MAJOR PROJECT- MP10_0195
Review of Environmental Assessment Report -
Warnervale Town Centre

Jim Tsirimiagos
Manager Land Use and Planning
RailCorp Property

Sheet name
AREA & CARPARKING SCHEDULES

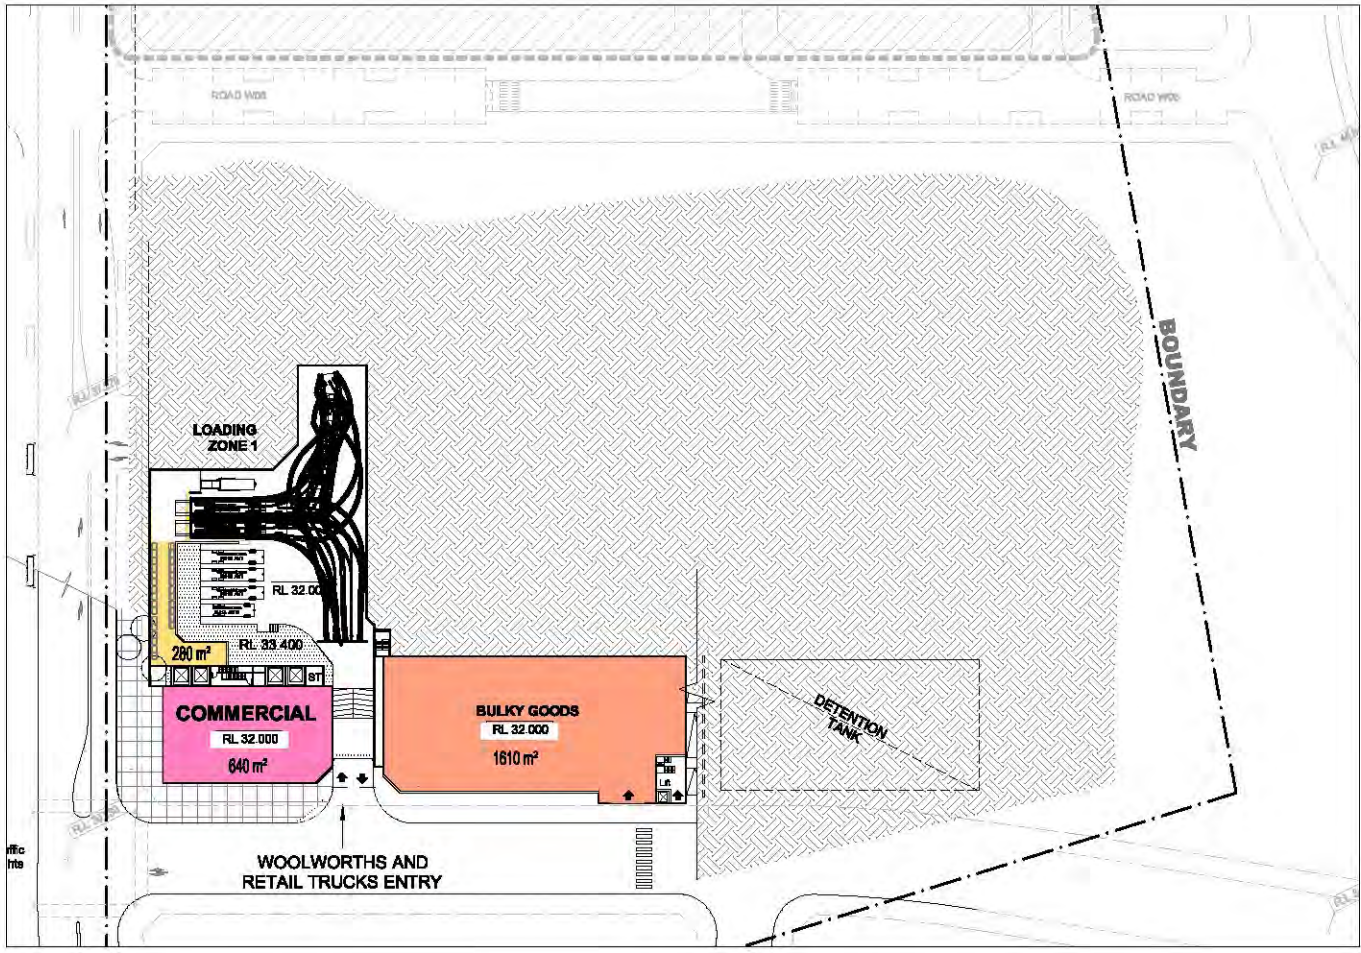
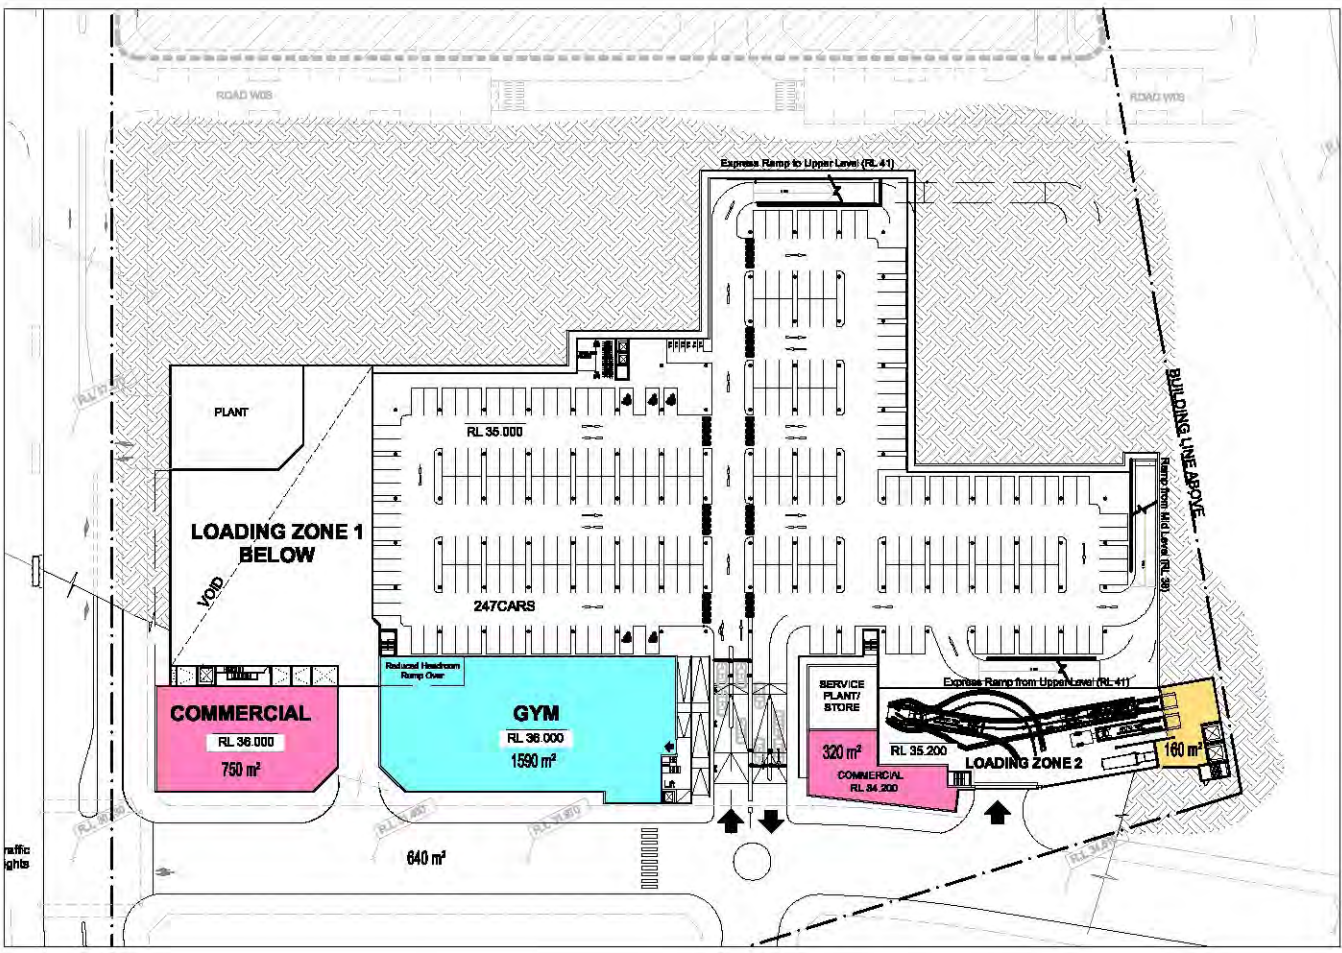
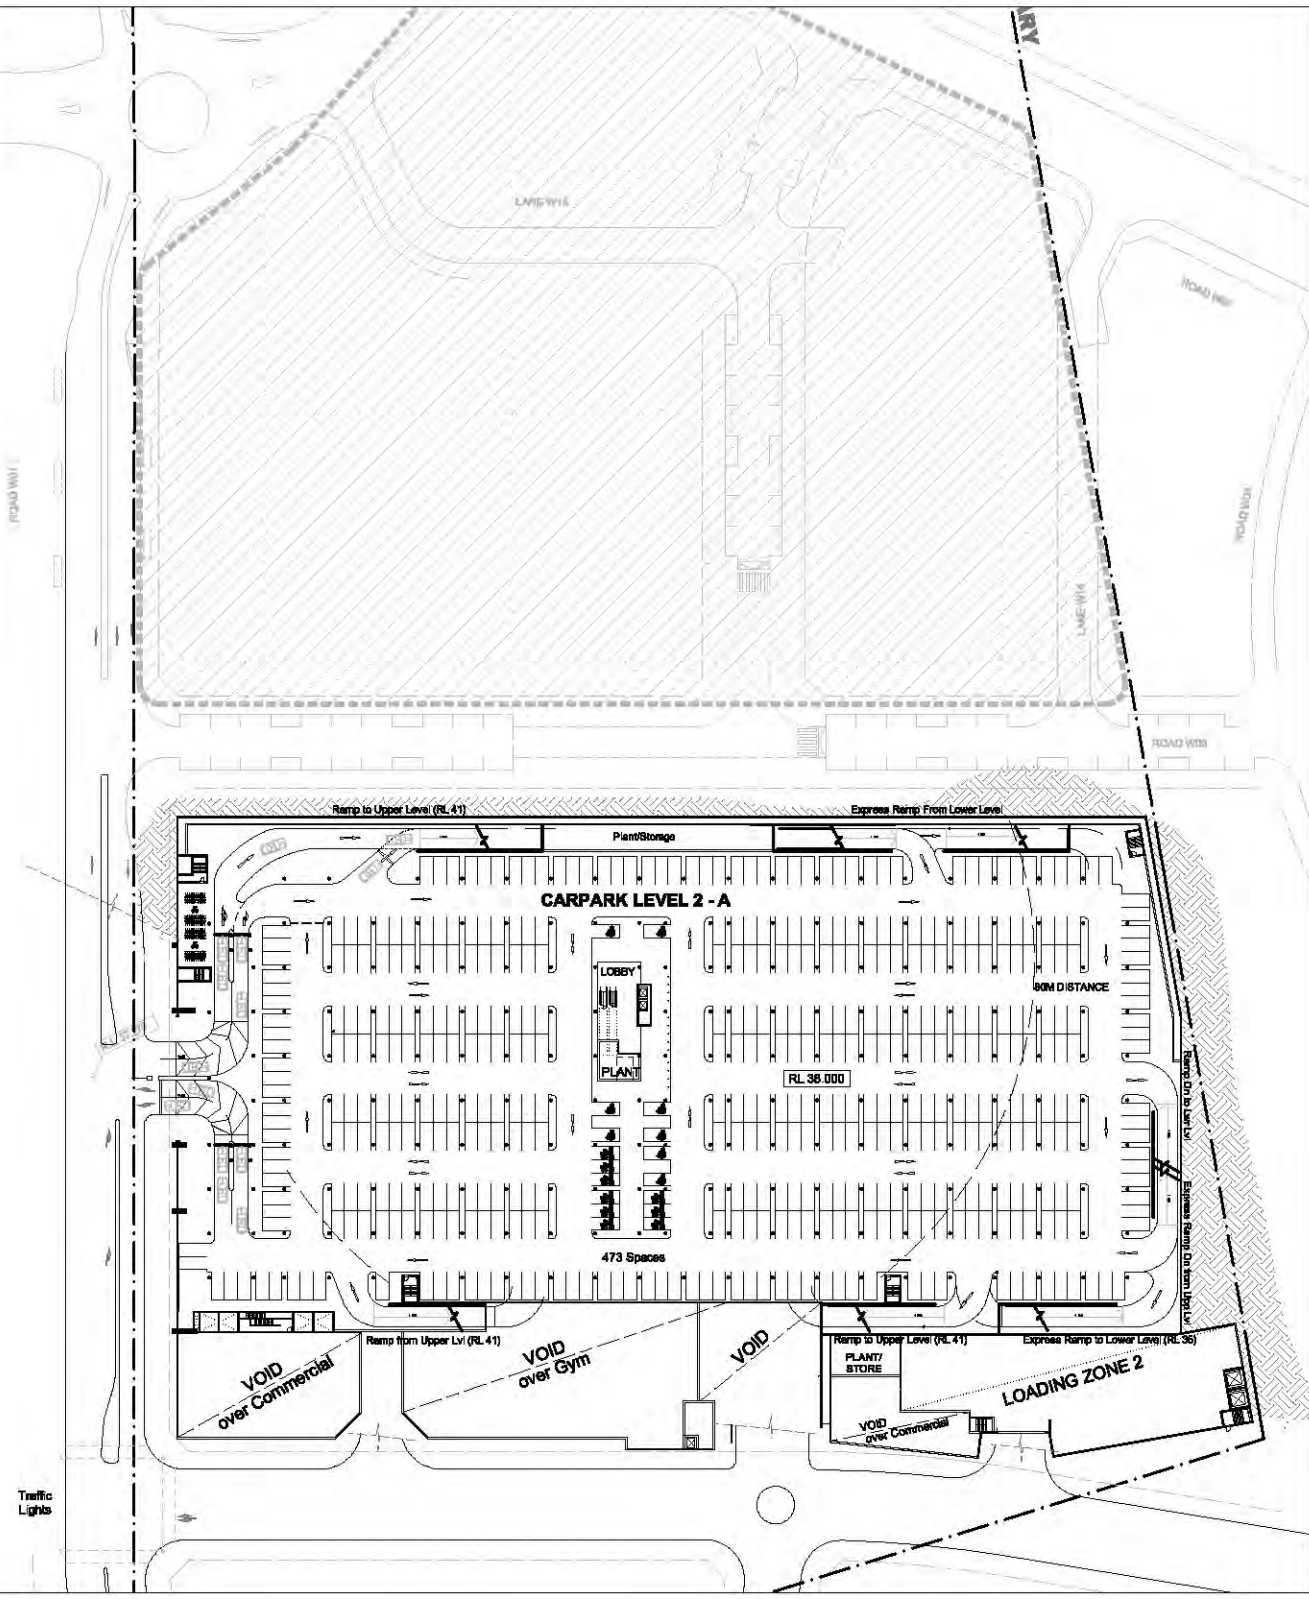
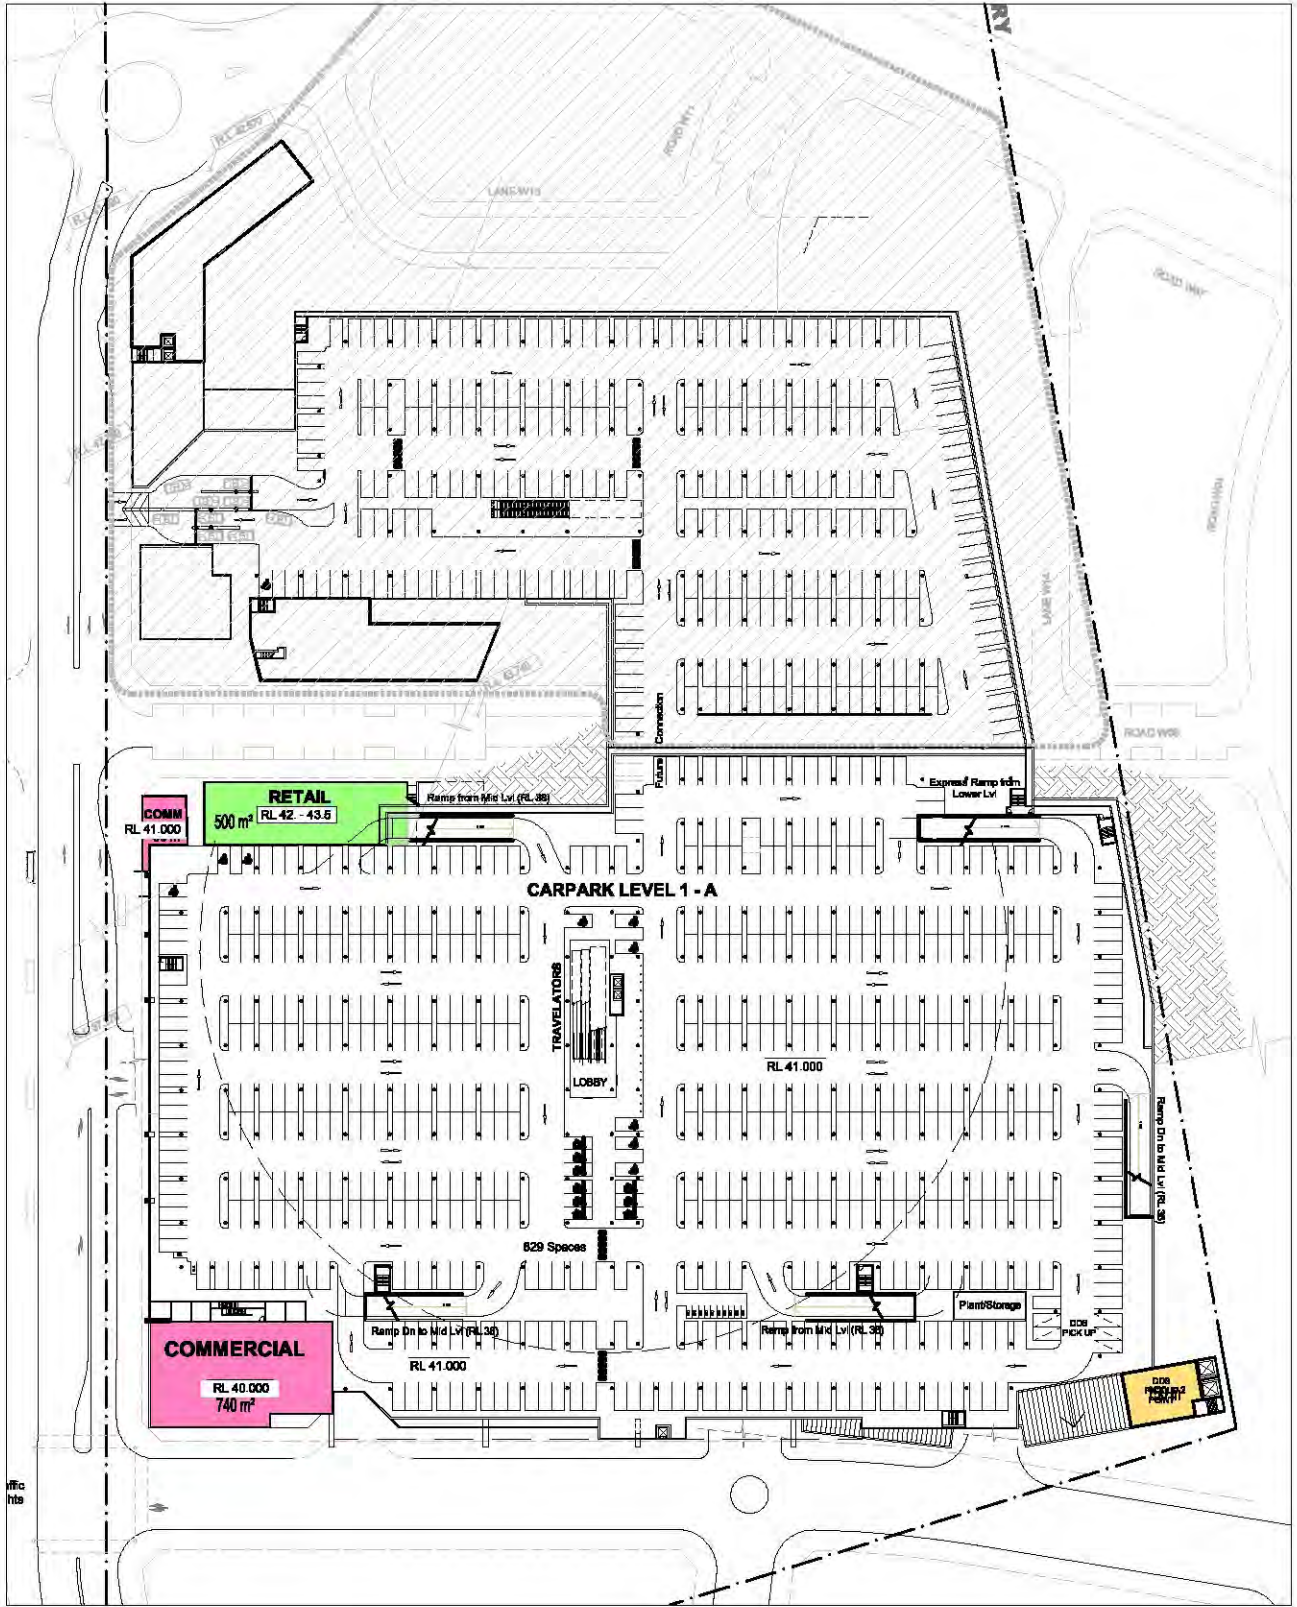
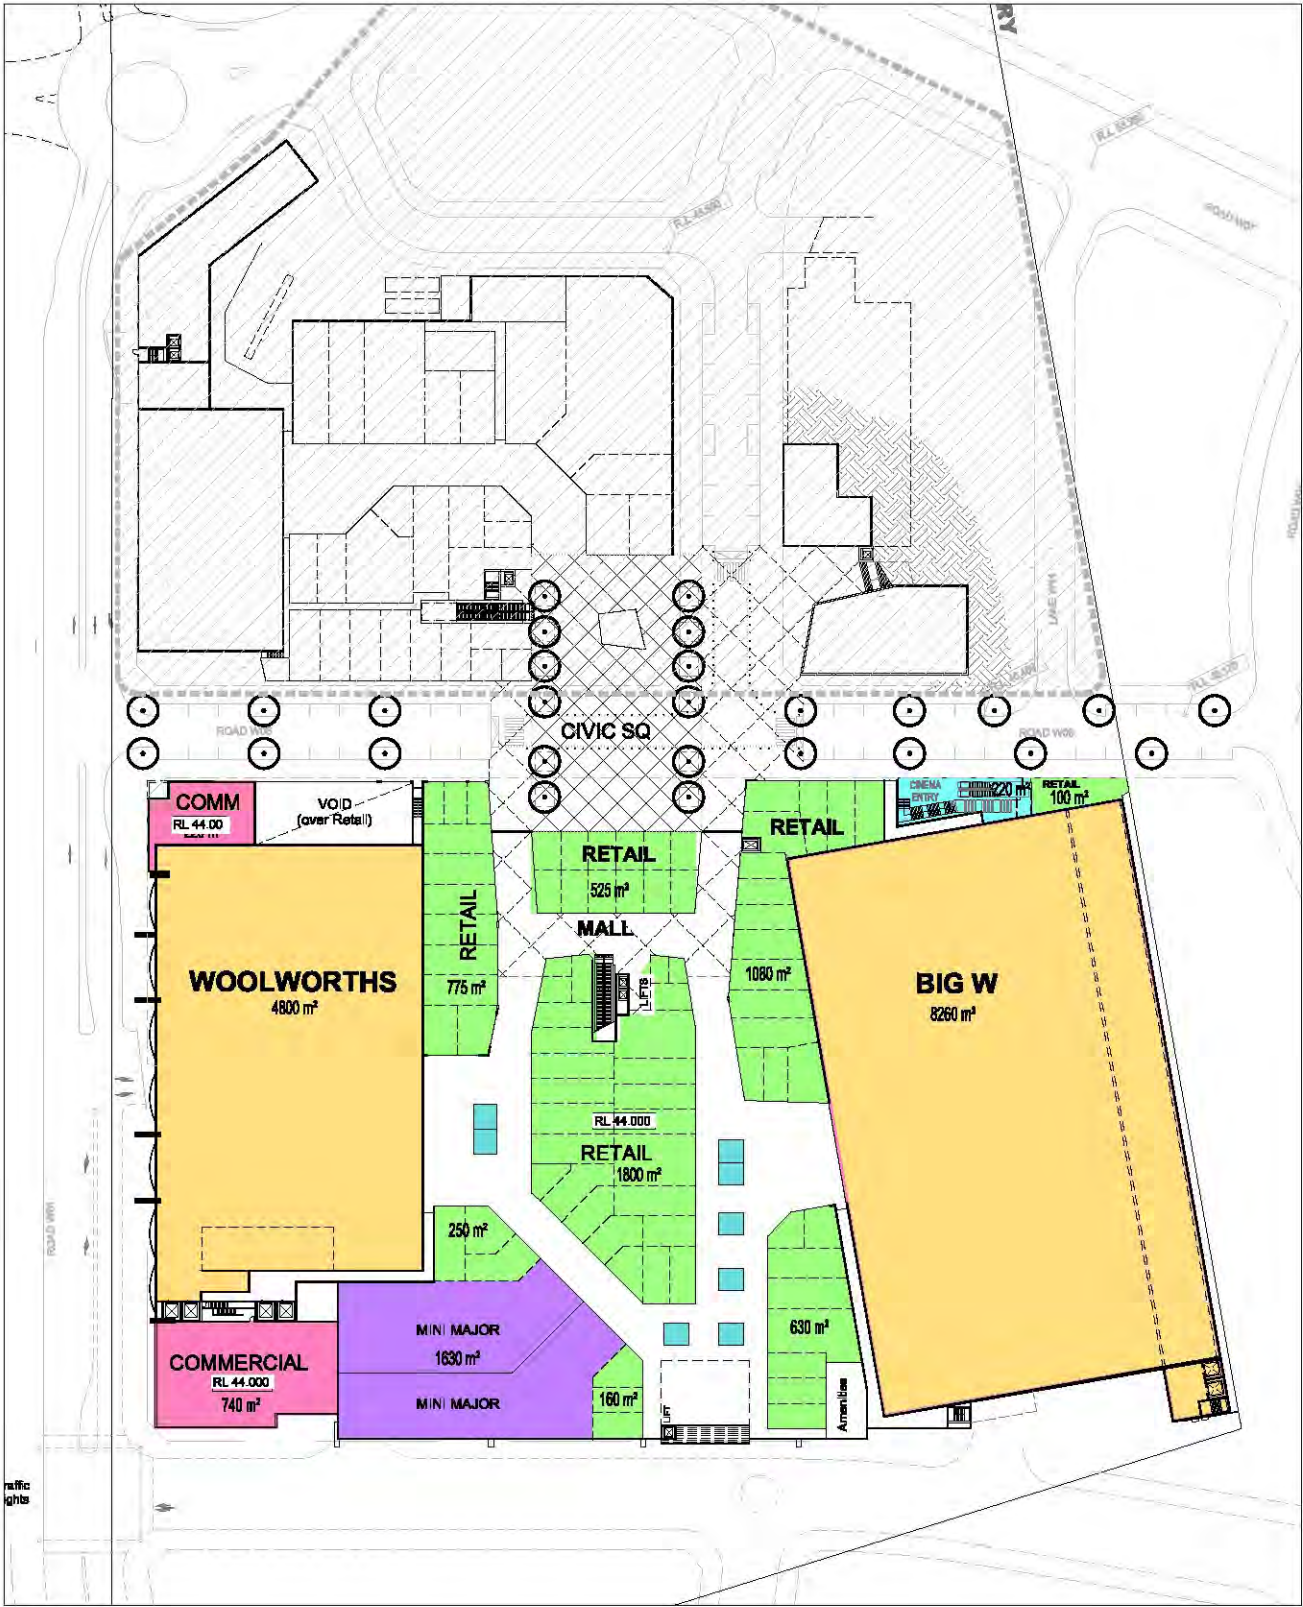
The proponent has made allowances for a total of 1880 car parking spaces for retail commercial and commuter use. The Environmental Assessment for the proposed development states that *"500 car spaces are to be provided for commuter car parking"*. However, out of the 1880 car spaces provided only 220 are identified for commuters in the transport report. RailCorp requests that the Warnervale Environmental Assessment provides an indication on the proposed location of the remaining 280 spaces for commuter car parking along with details on how these commuter spaces will be distinguished from retail and commercial spaces.
